PLANNING DEPARTMENT – Development Review Services

**RE: Generations at West Mesa
Grading & Drainage Plan
Engineer's Stamp Date 12-22-2015 (File: K11D084)**

Based upon the information provided in your submittal received 12-22-15, the above referenced plan is approved for Site Plan for Building Permit

GRADING &
DRAINAGE PLAN

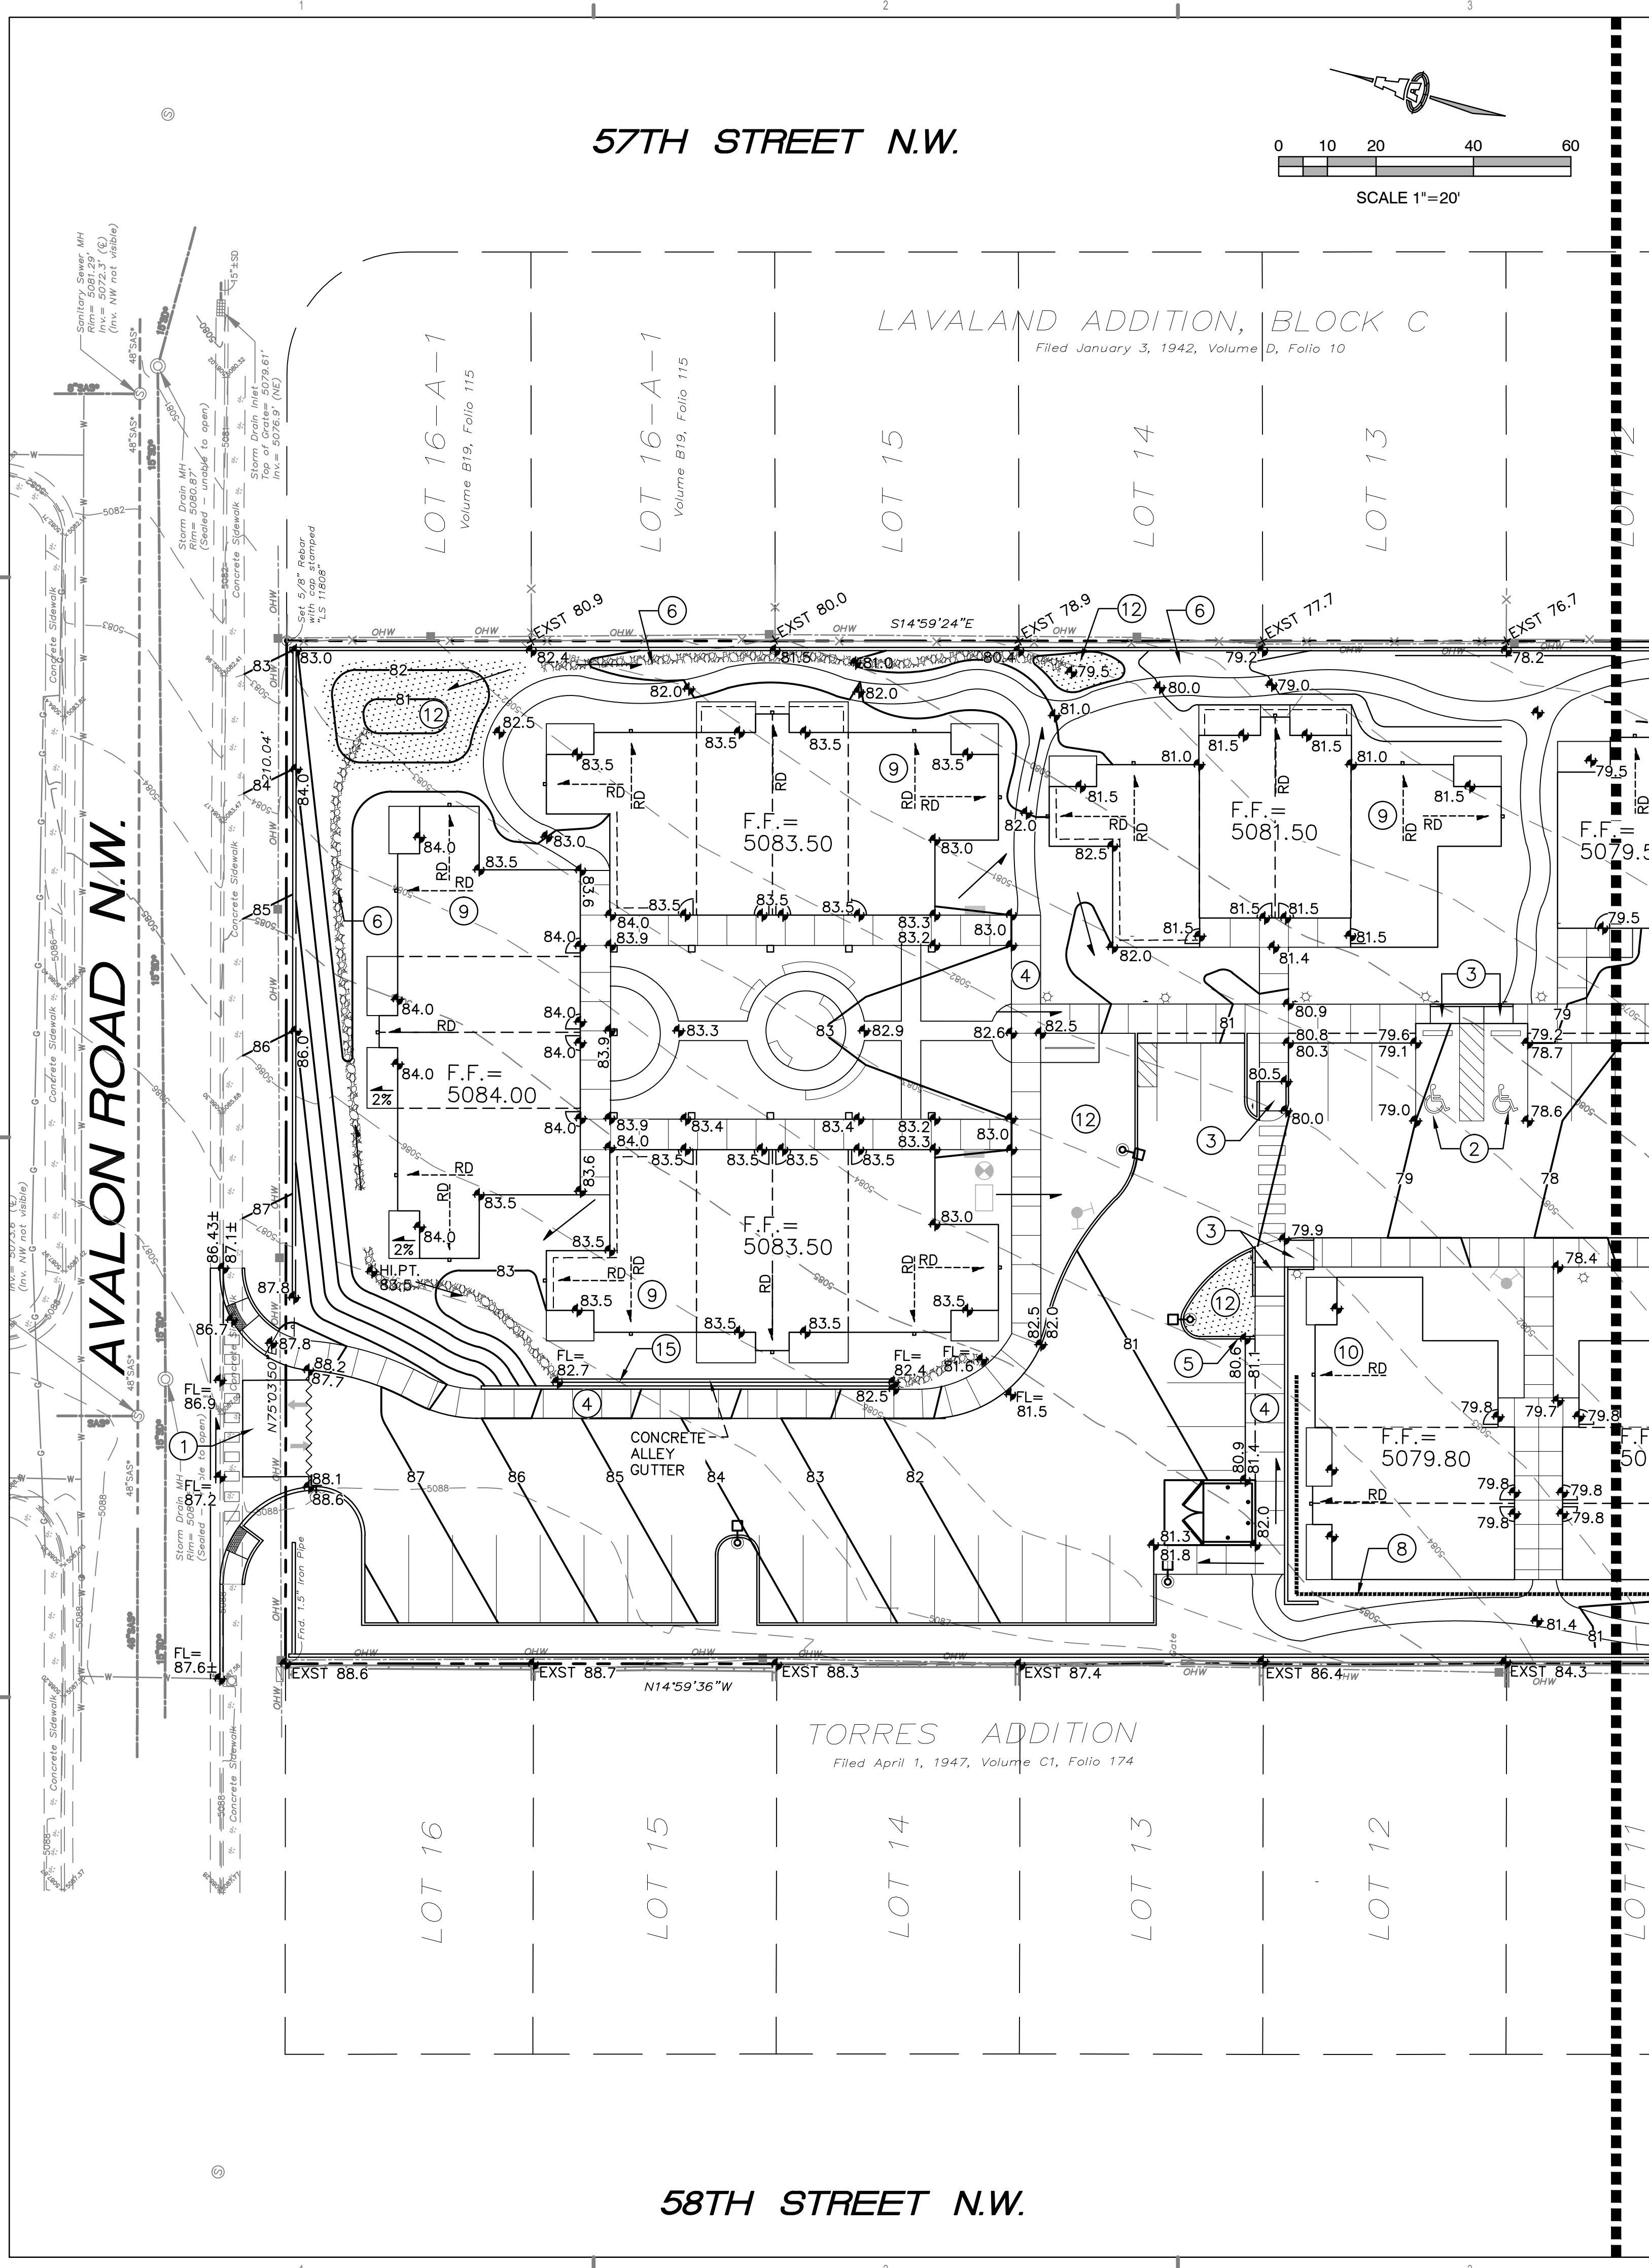
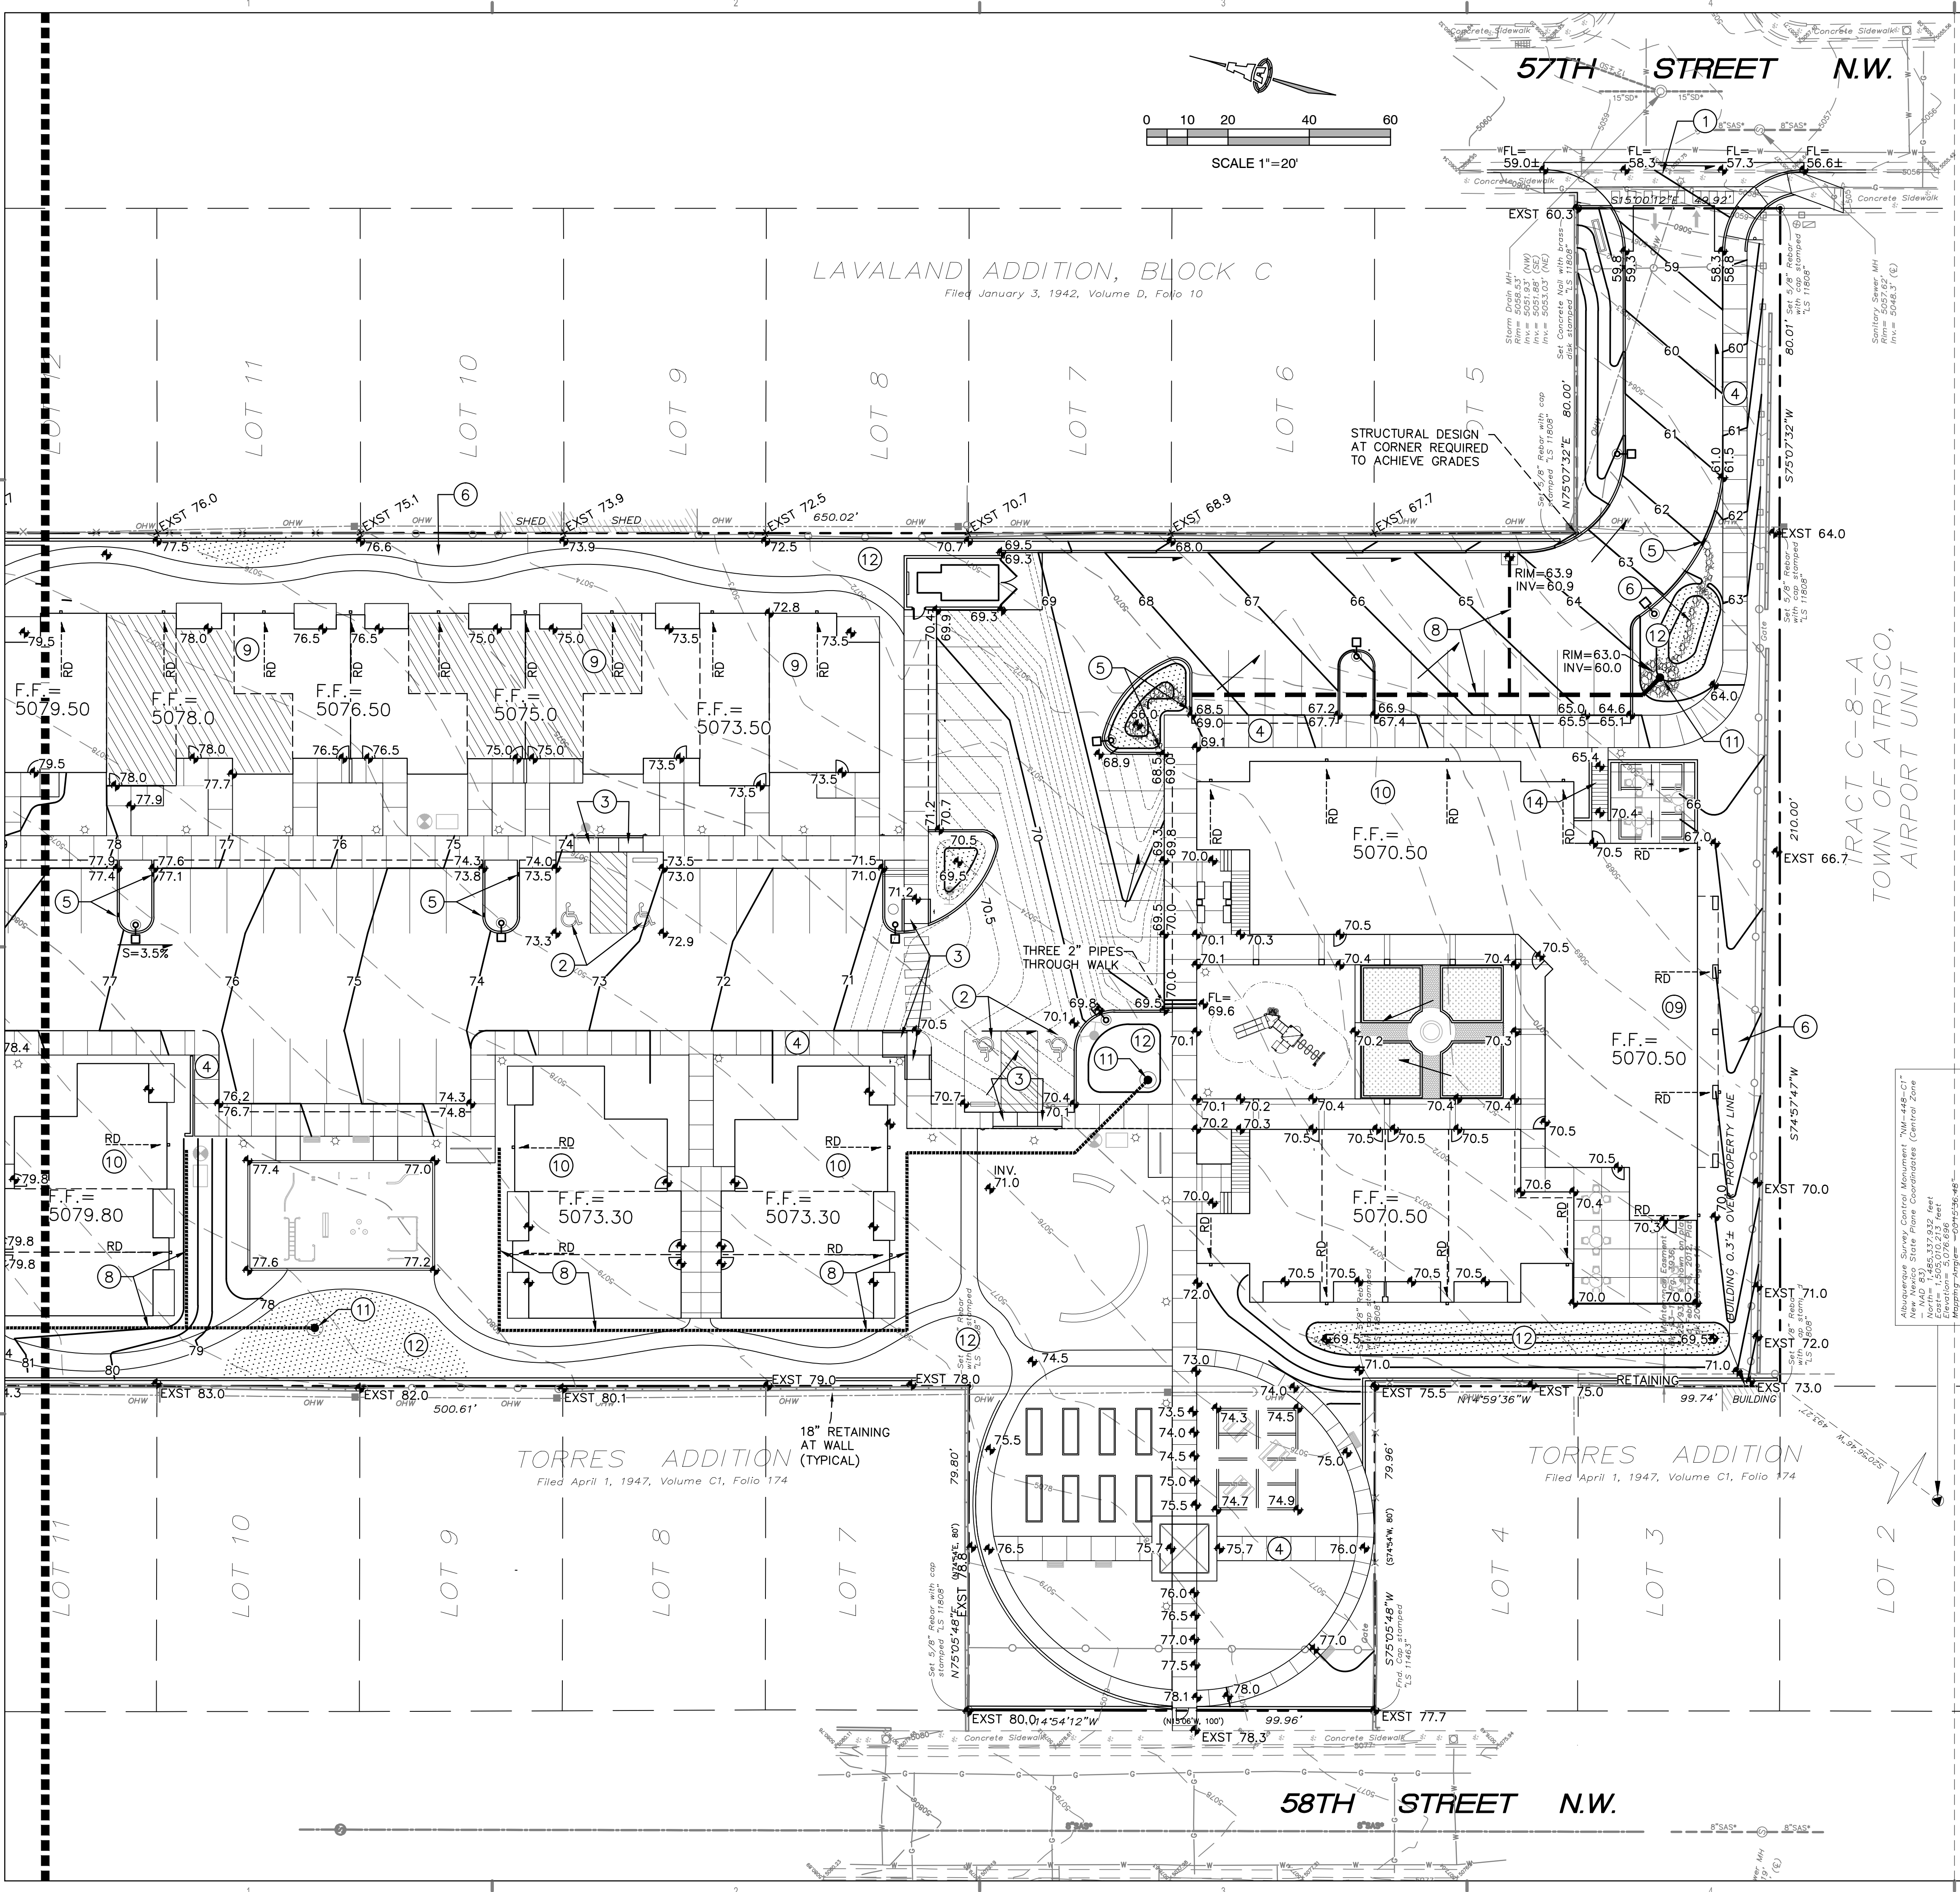
1. Since you are opting to discharge into 57th Street, provide street capacity calculations.
2. Show retaining wall locations, with T.O.W. and B.O.W. elevations.
3. Note any existing walls along boundaries
4. North side of site: provide SW culvert beyond alley gutter
5. Along East and West side of site, provide positive flow path. Provide a section and adjust sidewalk to allow for flow path.
6. Provide a curb cut so swale along eastern edge discharges to driveway
7. Call out inlet on east side of driveway
8. South side of site: provide SW culvert so discharge enters first flush pond
